DECISION DELEGATED TO HEAD OF PLANNING

Application No: H03-0700-24 **Applicant:** Mr & Mrs C Constable
Proposal: Proposed two storey rear extension
Location: Chapel Cottage Main Road Hop Pole
Terminal Date: 15th October 2024

Proposed Ground Floor Plan
Scale 1:50

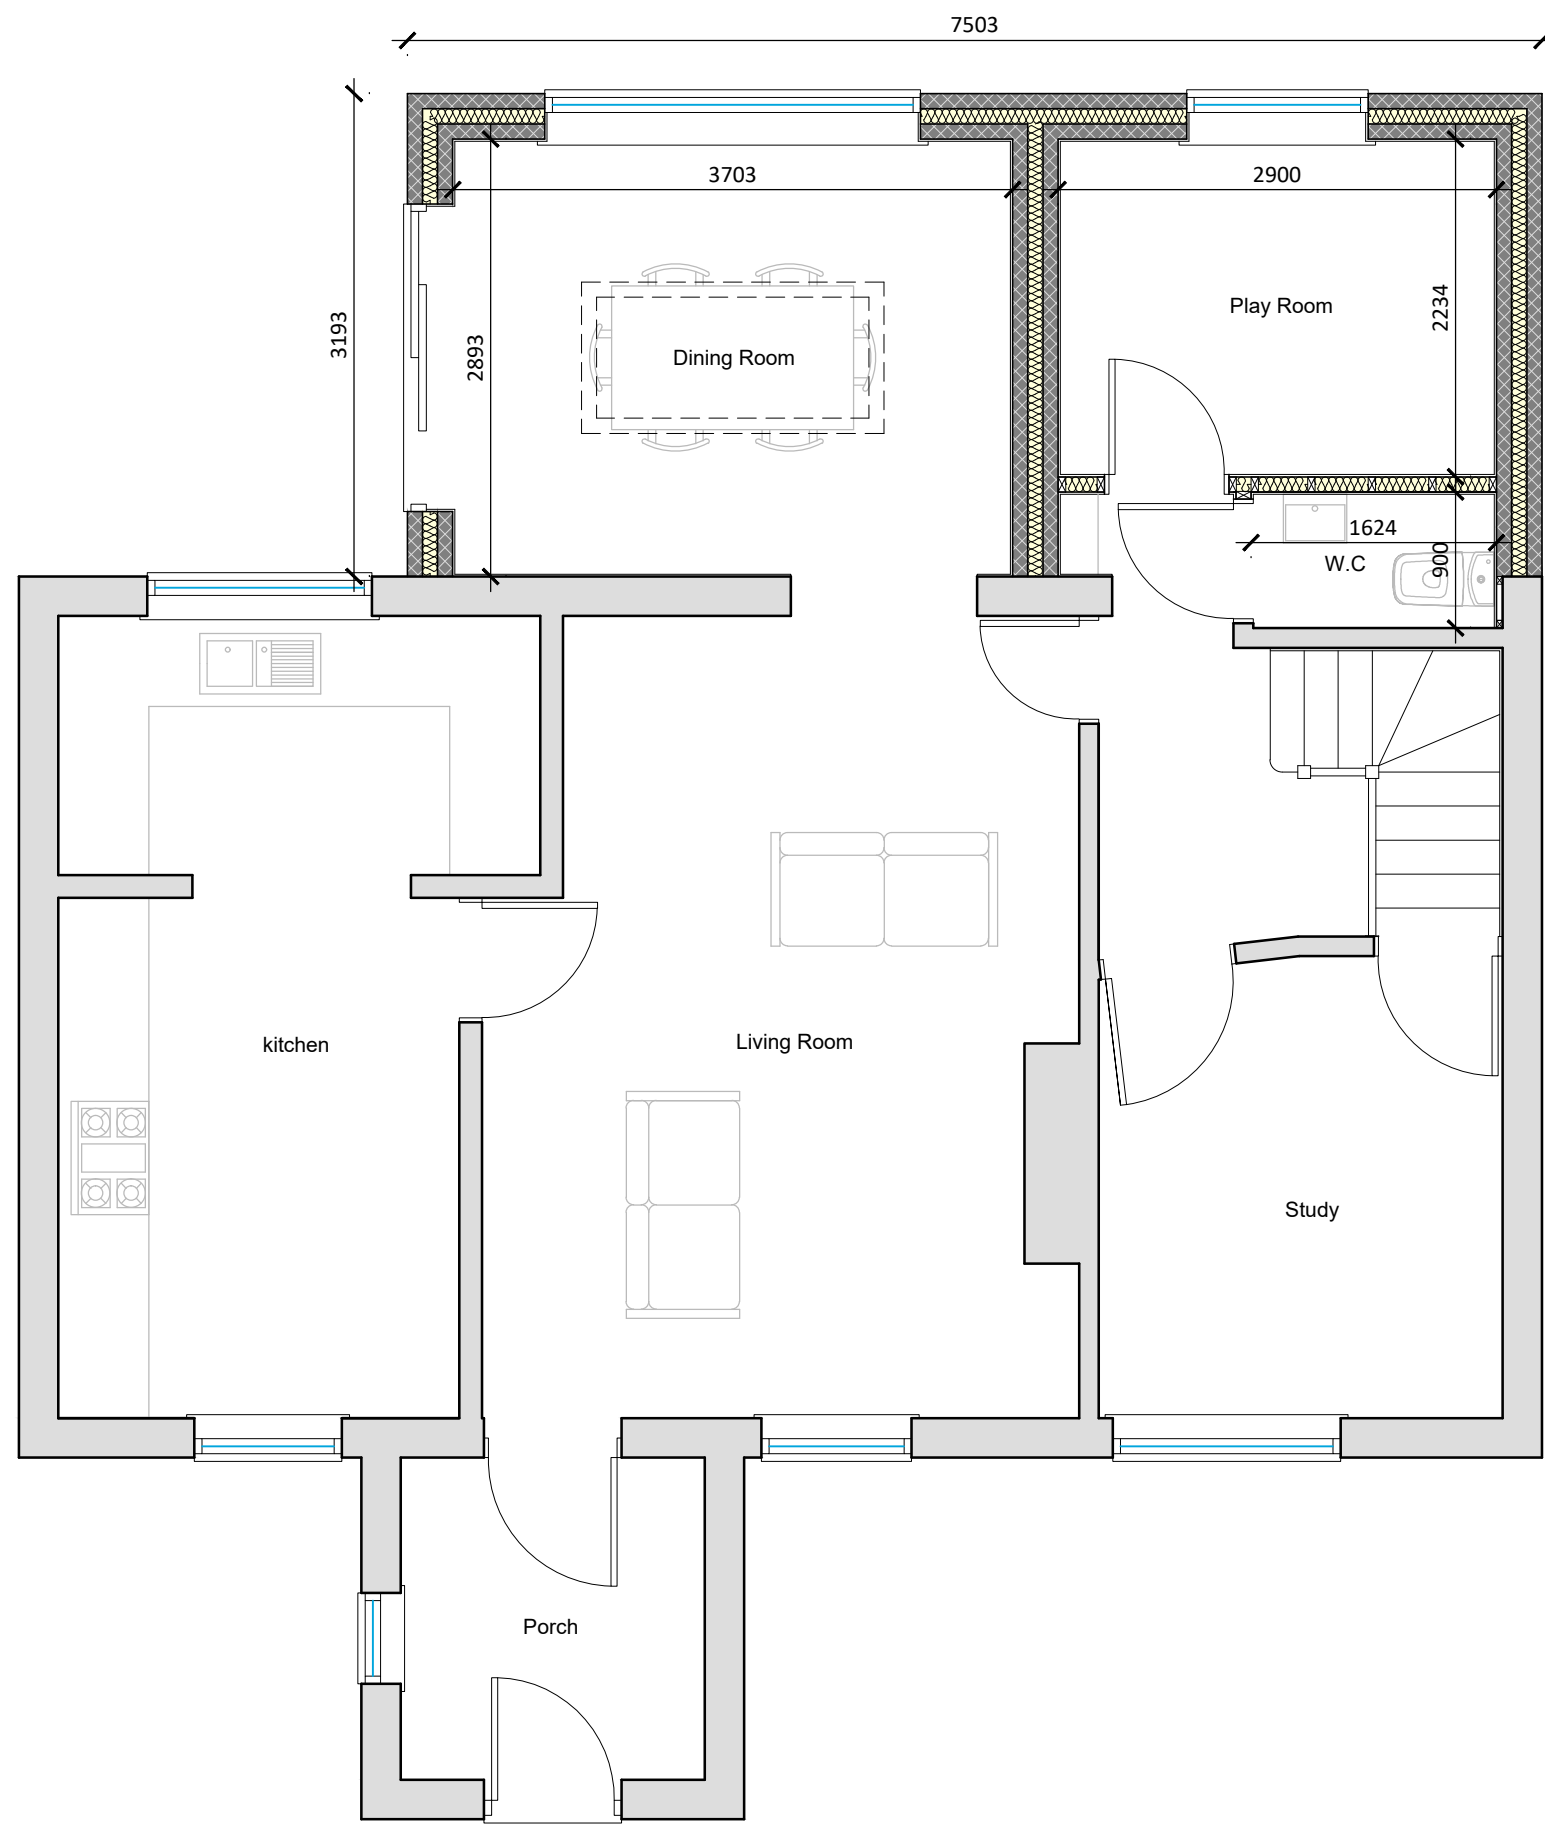
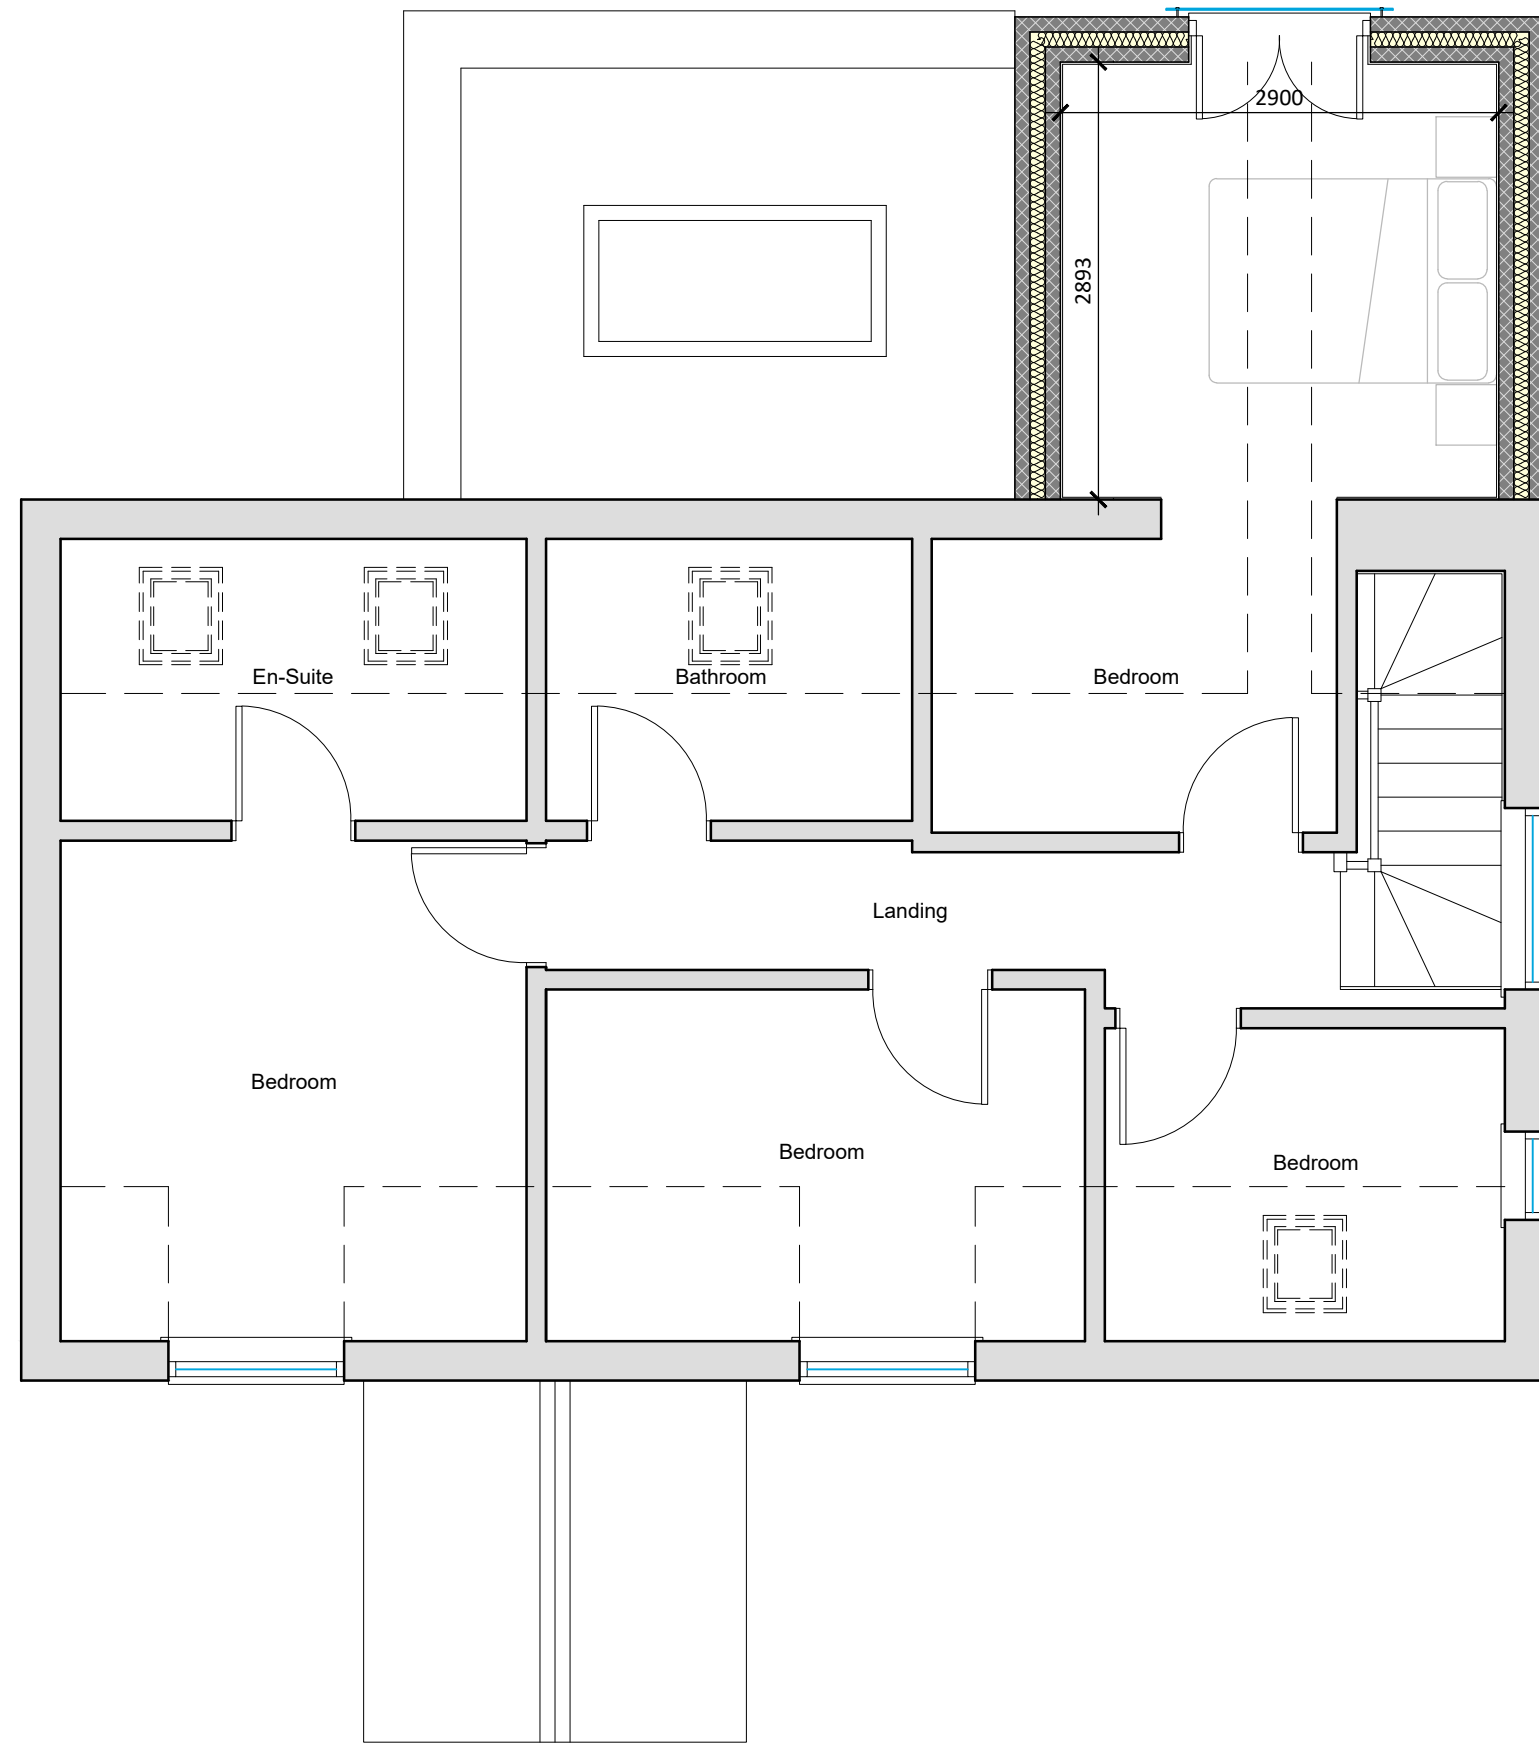
There will be some internal alterations as part of this application including the demolition of the existing conservatory to allow for the proposed extension. On the ground floor the new rooms will be a dining room, play room and a WC. The rear bedroom will be opened up into the extension in this instance and will feature a Juliet Balcony on its rear elevation facing outwards to large open farming fields.

Proposed Rear (NW) Elevation
Scale 1:100

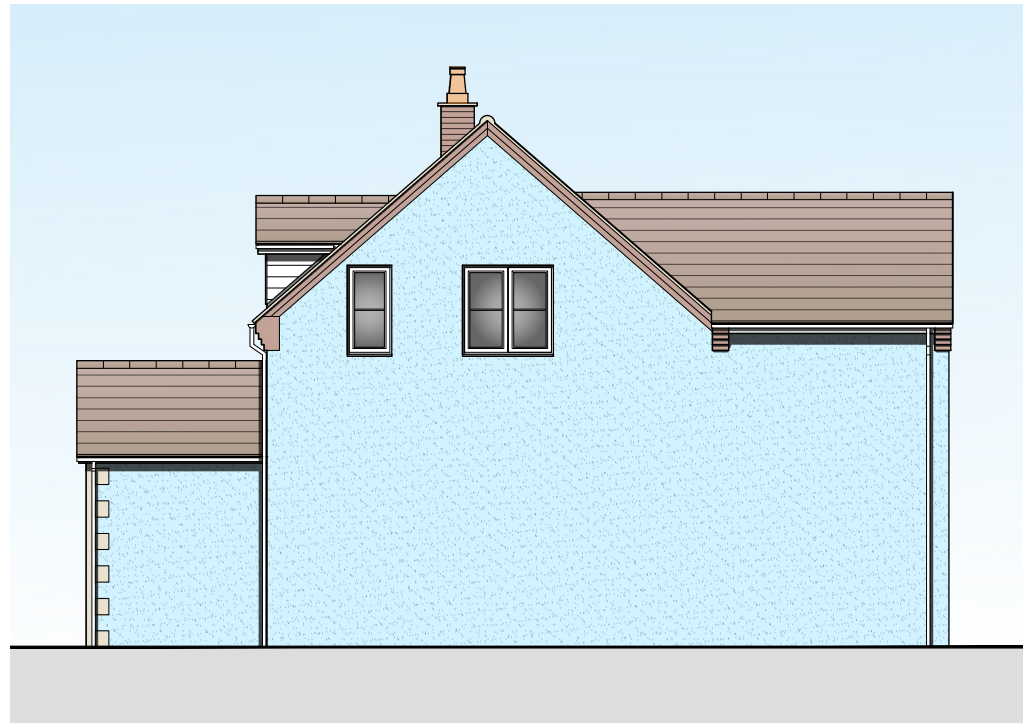
From the rear elevation the extension will protrude by approximately 3193mm and will have a total length of 7503mm. The first floor section will be slightly less than this projecting out by the same distance but being slightly shorter in length sitting at 3500mm. It will have a ridge height of 6000mm allowing it to appear subservient and subordinate in comparison to the host property whereas the eaves will be level with the existing being 4200mm. Finally, a smaller flat roof section will have a total height of 3000mm - although this is a flat roof and therefore not commonly favourable to the LPA as it is located to the rear of the site and not visible from the highway it is considered to be acceptable in this instance.

The new window to the rear elevation will not result in a loss of privacy to any surrounding residential property as it will face to the rear and outlook onto large open fields where there are currently no residential dwellings or development. Furthermore, the extension on the first storey is minute plus there are more than adequate separation distances between the neighbouring sites which ensures that there is no material overshadowing either.
